EPC STORMWATER REVIEW COMMENTS  
IN ORANGE BOXES WITH BLACK TEXT

# EASTWOOD VILLAGE 1249 MEADOWBROOK PKWY PRELIMINARY PLAN

EASTWOOD VILLAGE  
EL PASO COUNTY, COLORADO  
PRELIMINARY PLAN  
COVER SHEET

EASTWOOD VILLAGE  
EL PASO COUNTY, COLORADO  
PRELIMINARY PLAN  
LOT DIMENSION PLAN

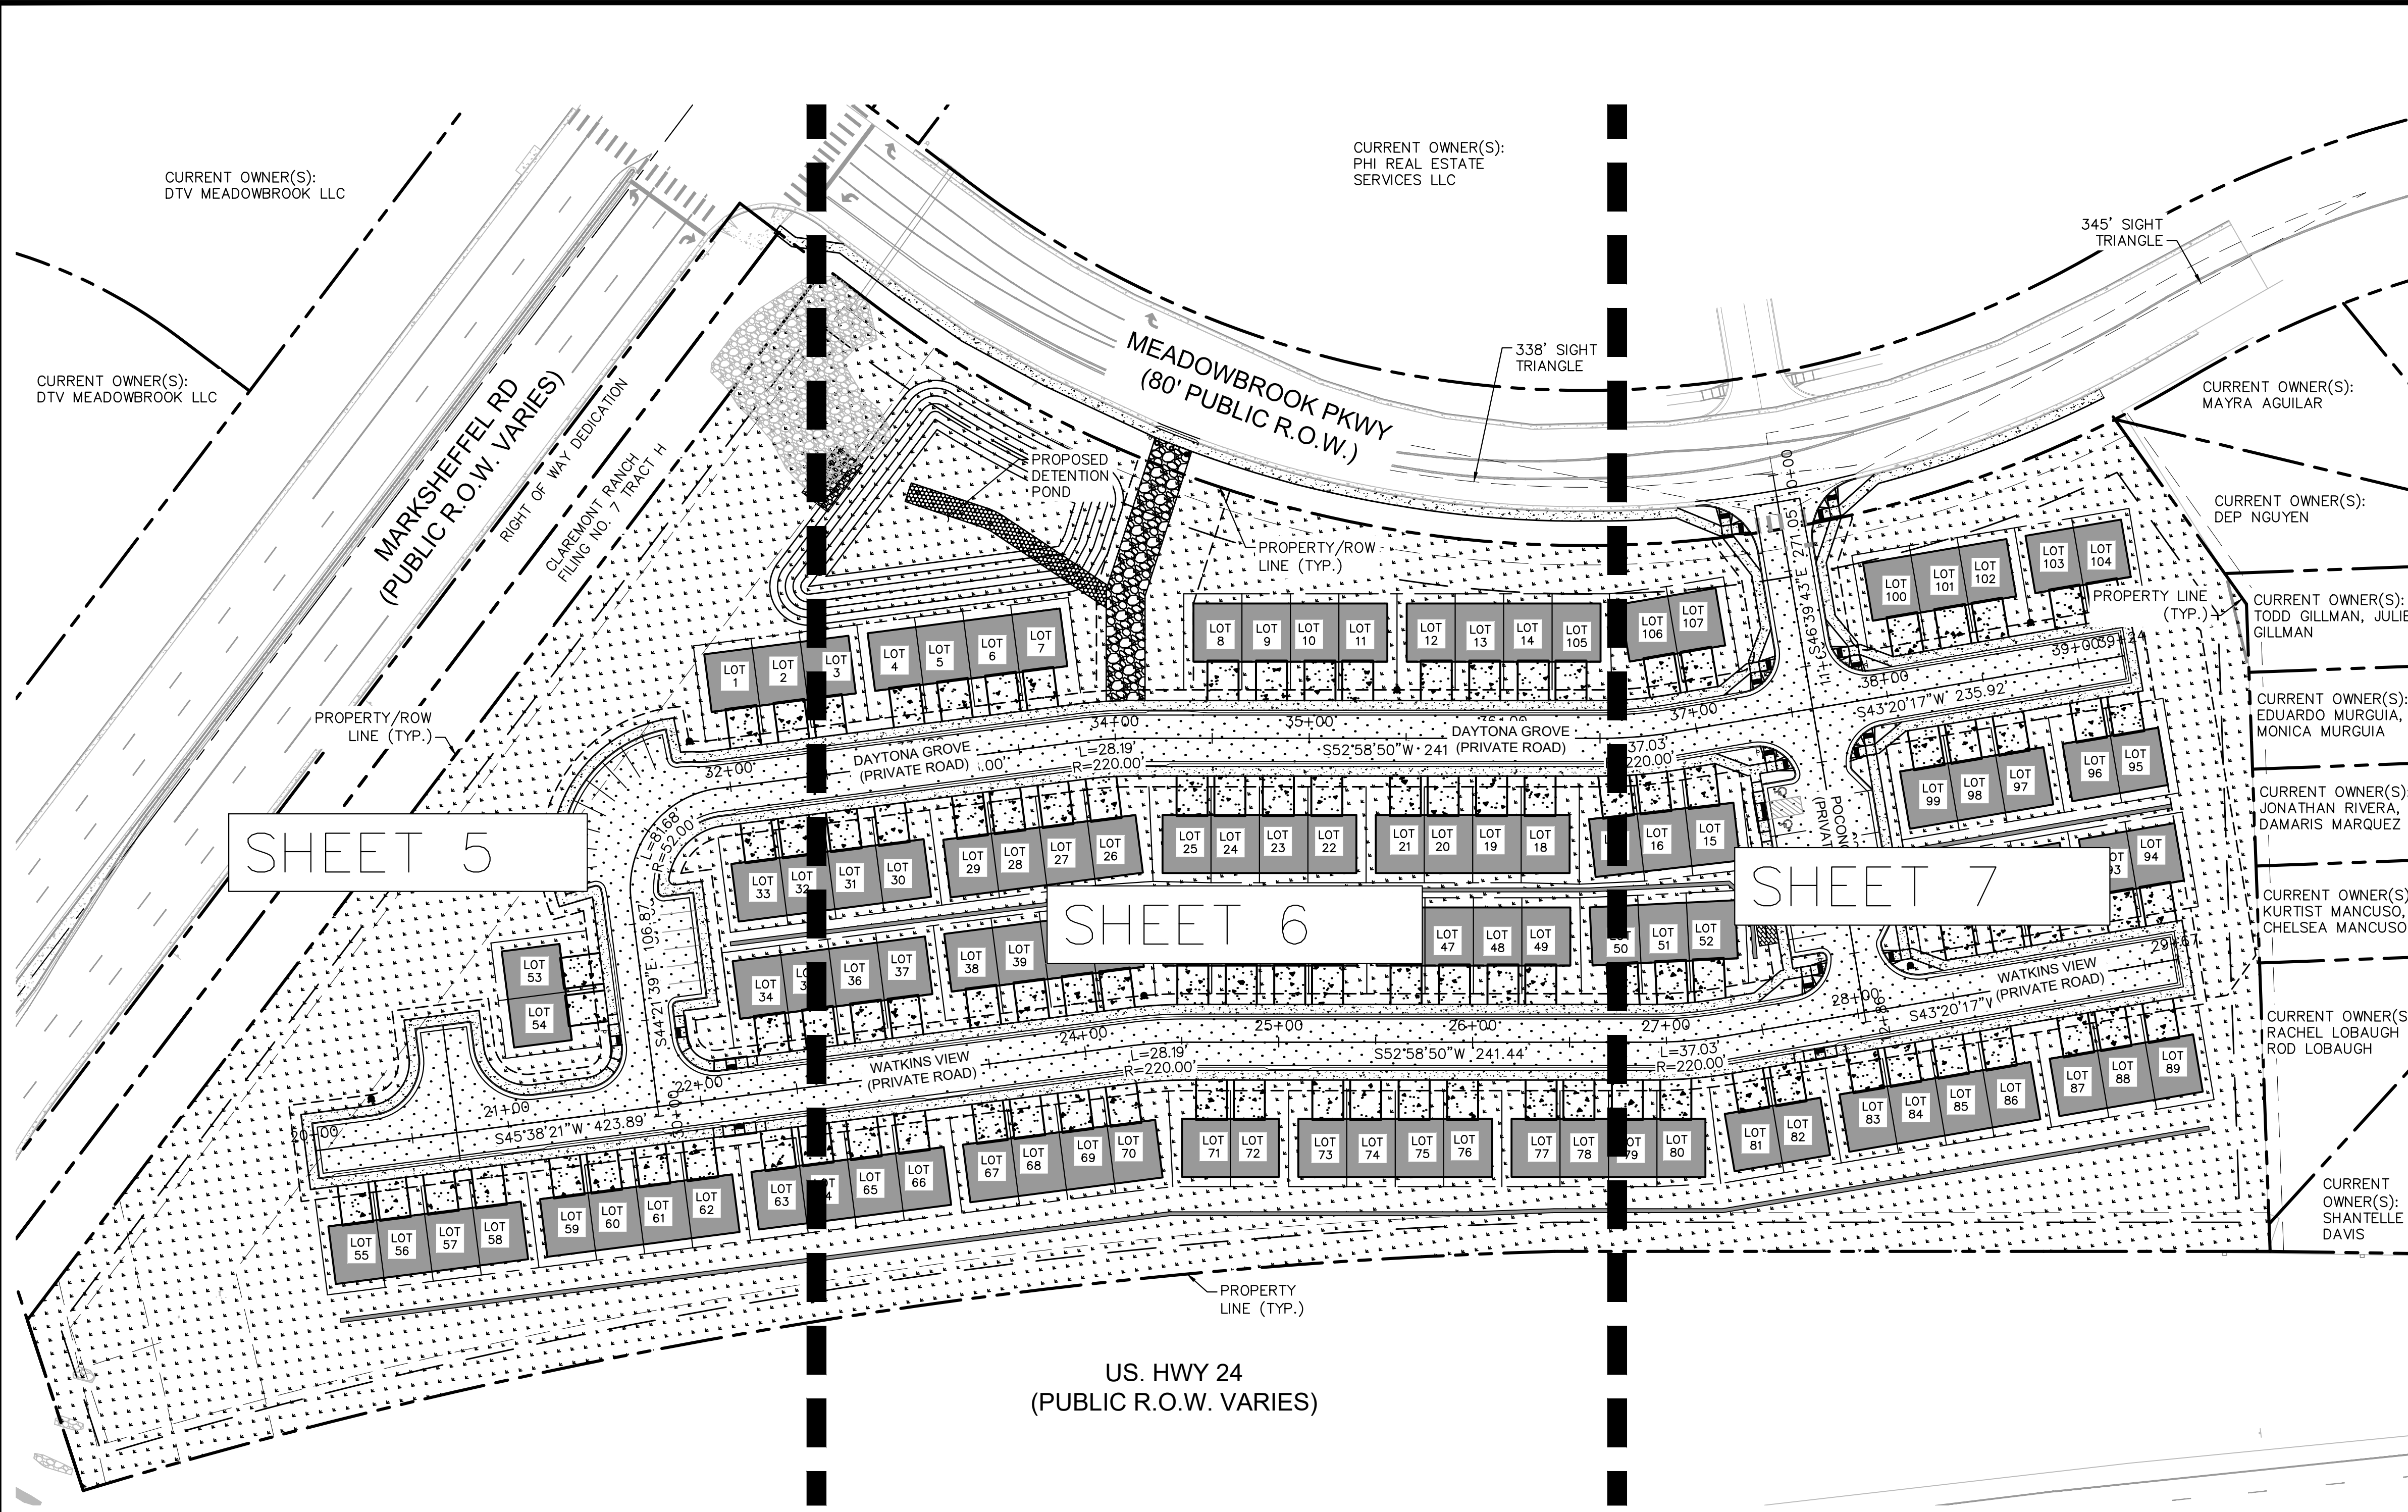
Label if this is emergency access location, as mentioned in LOI. Ensure design of access roads has approval from fire district and meets their standards.

Remove this cross ramp, as due to traffic volume, should limit crossing locations for pedestrians. Provide a deviation for not installing this ramp

Include receiving ramp on this side of Meadowbrook Pkwy

Label Lines

Please number the lots sequentially. The lot numbering scheme you have provided is challenging and difficult to follow to ensure there are no duplications or omissions.

Label Highway 24

Additional ramp may be necessary if distance between proposed ramps is greater than 600'. Refer to ECM section 2.5.2.C.4

Per ECM 2.3.8 roadway terminations shall be cul-de-sacs. Please provide deviations for not providing a cul-de-sac and be sure to include approval from fire district with design shown.

This development does not meet the lot size requirements of the RM-30 zoning district. Per Table 5-4, Density Dimensional Standards, RM-30 has a minimum lot size of 5,000 sq. ft. The following footnotes apply:

EASTWOOD VILLAGE  
 EL PASO COUNTY, COLORADO  
 PRELIMINARY PLAN  
 OVERALL SITE PLAN

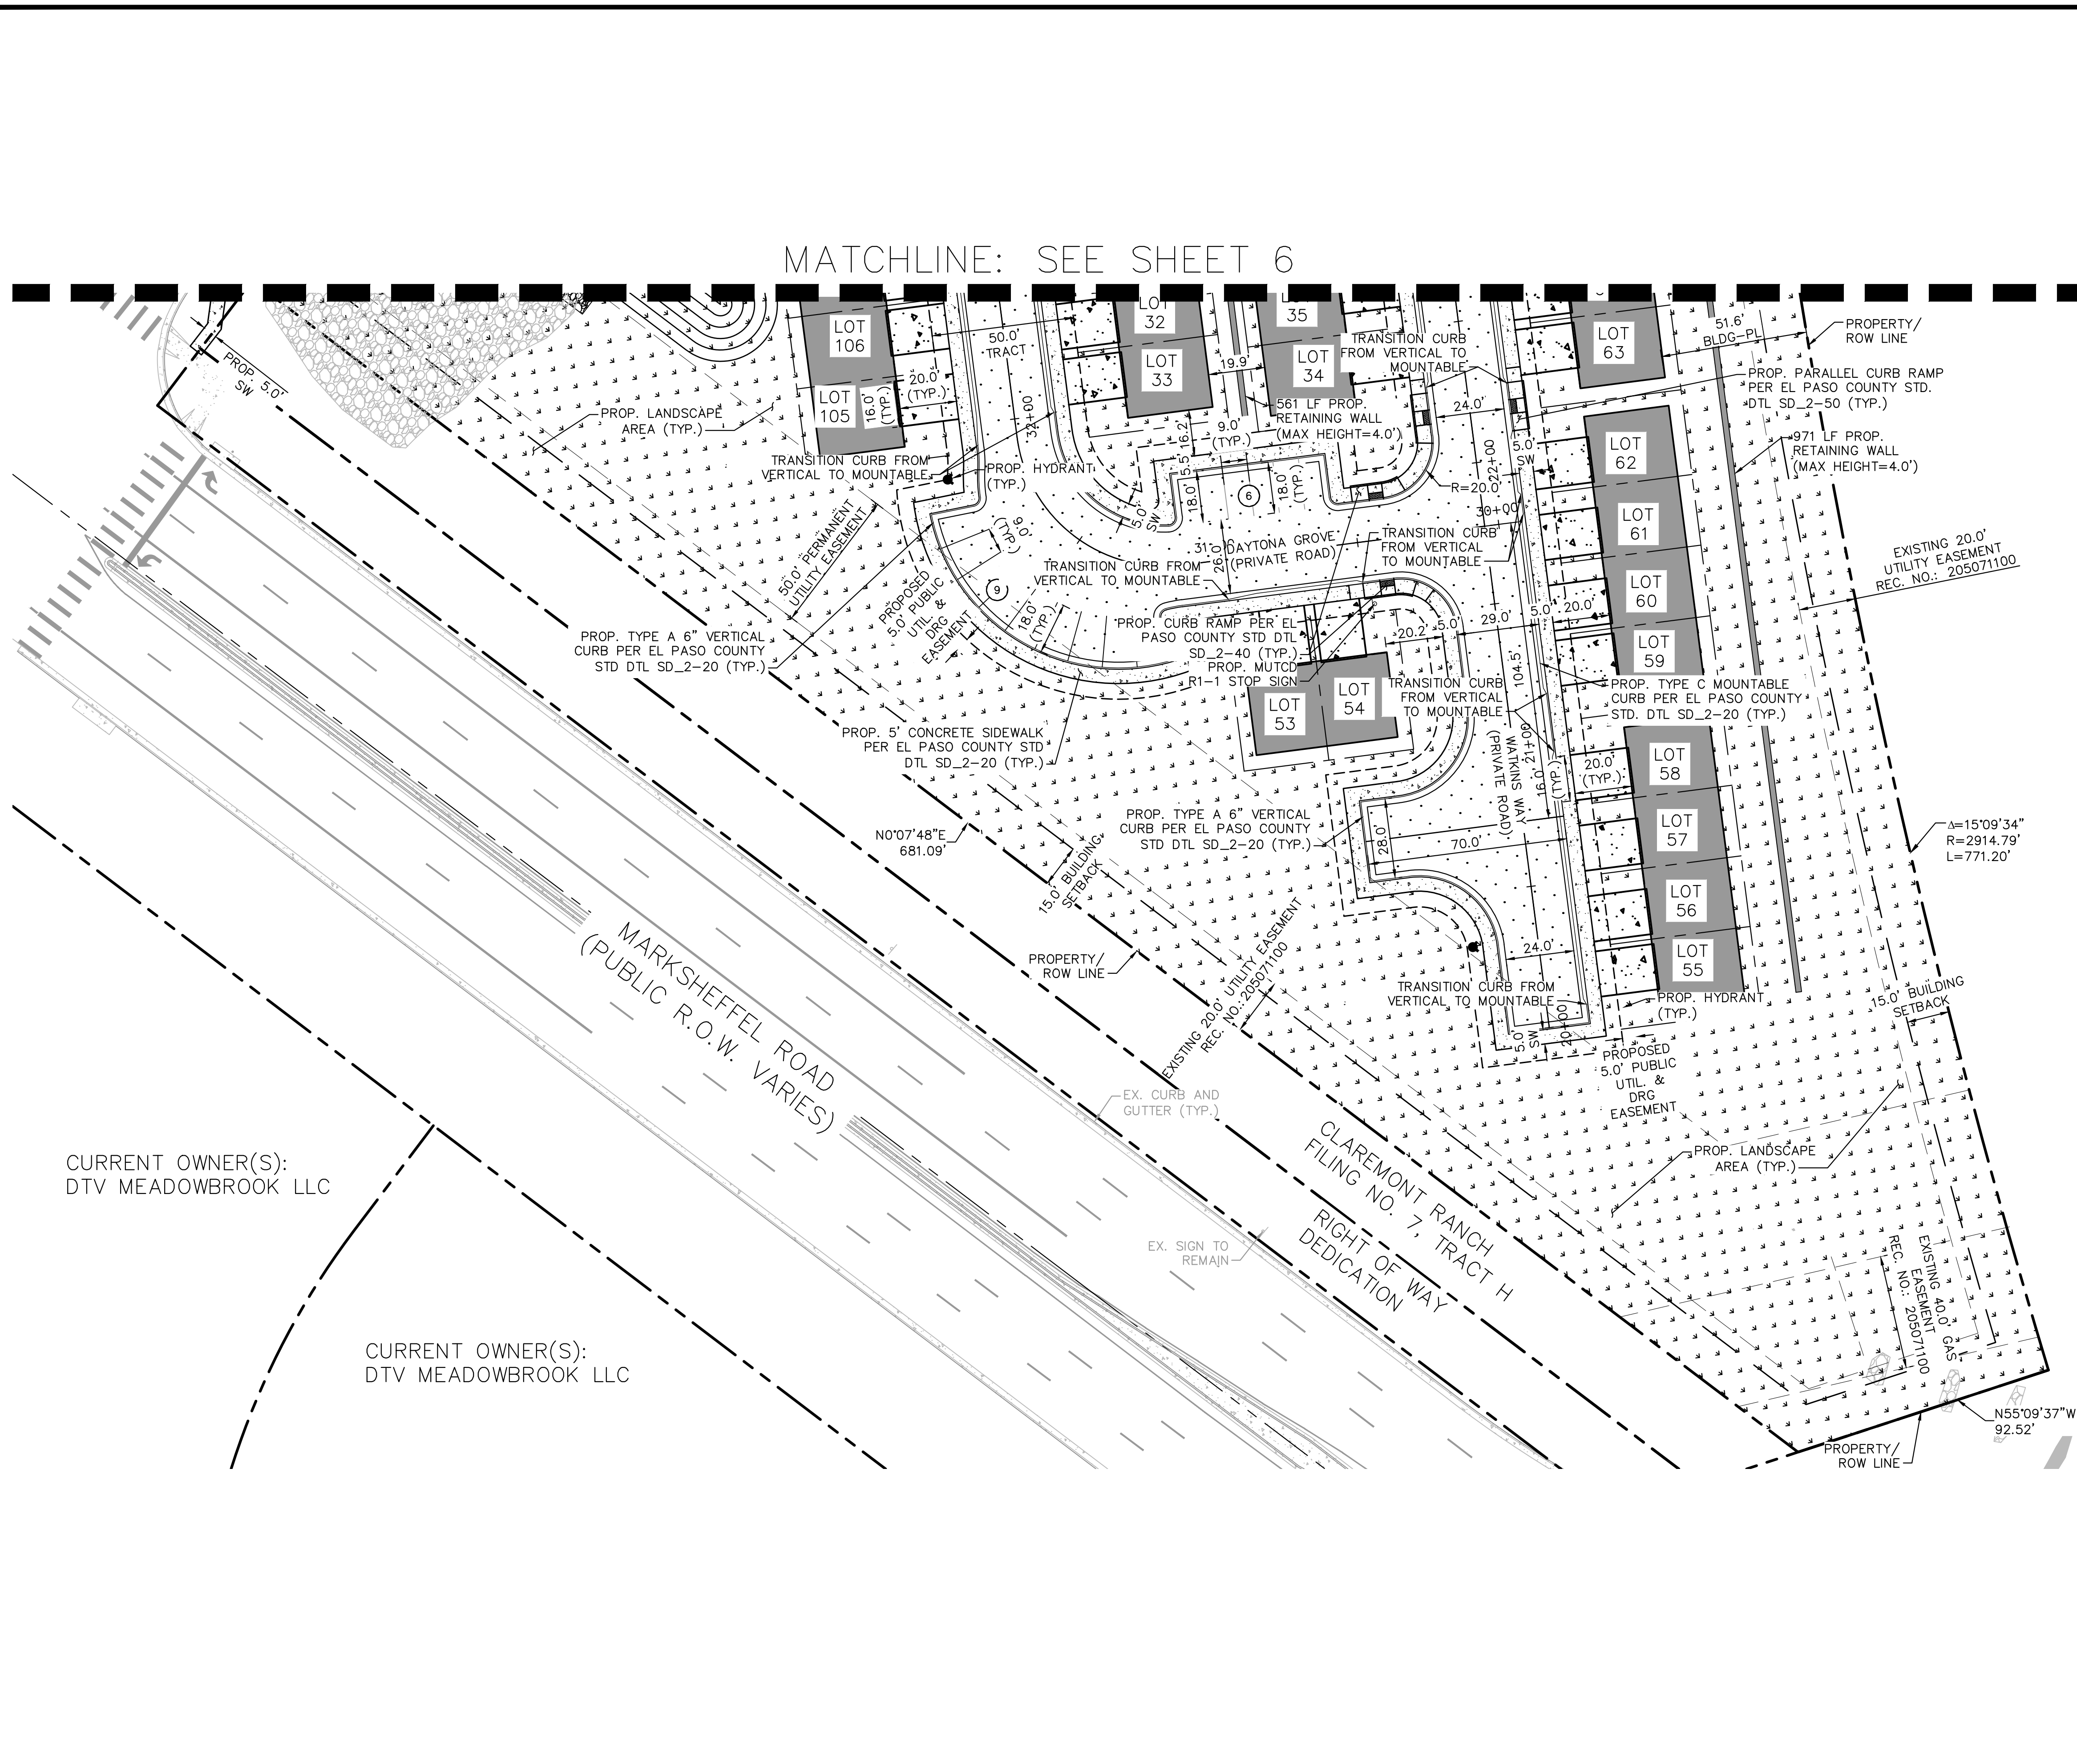
The SWMP states that water quality will be achieved through the use of a proposed detention pond and a rain garden - delineate the rain garden on the plans or update the SWMP text.

Sight distance triangle values do not match. Please verify sight distance requirements with traffic engineer and revise.

Label ST-1 and ST-2 on the plan.

**MSE BLOCK RETAINING WALL DETAIL (TYP.)**  
N.T.S.

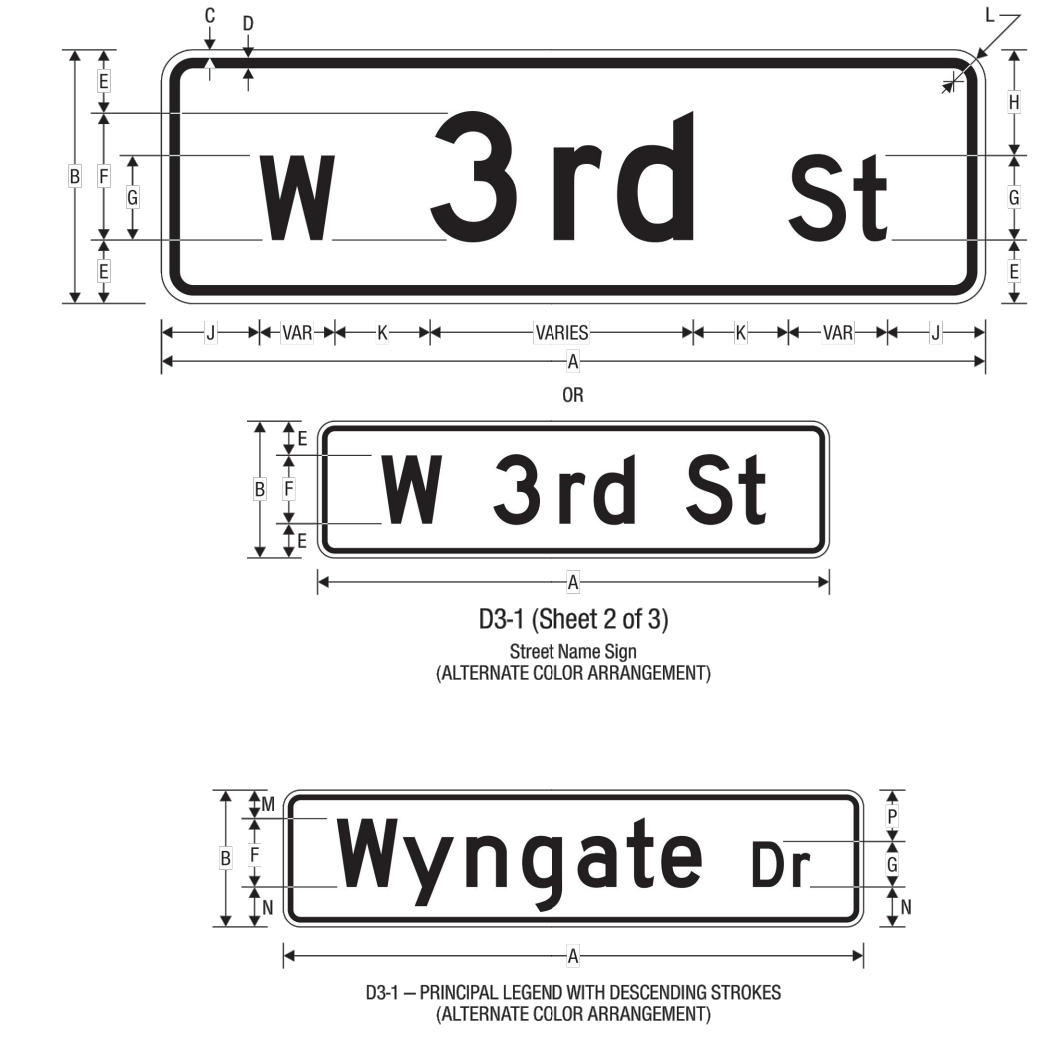
Callout this feature behind the retaining wall. Is this supposed to be drain rock? Clearly label for constructibility including the size on stone and thickness.

**CURB TRANSITION DETAIL**  
SCALE: 1" = 5"

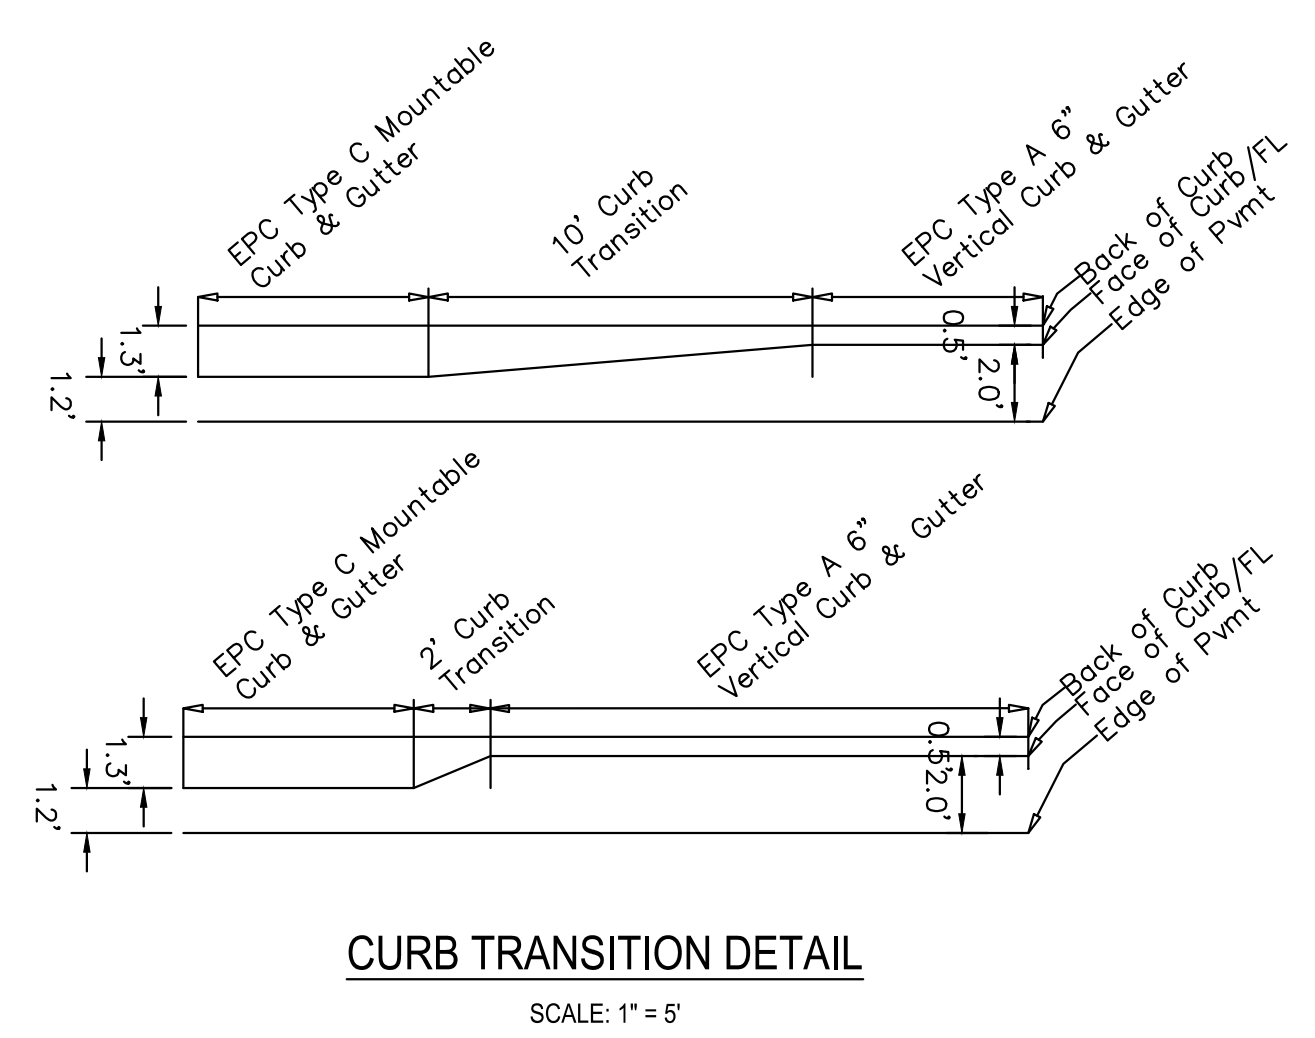
Need to differentiate on plan sheets which transitions are 2' and which are 10'.
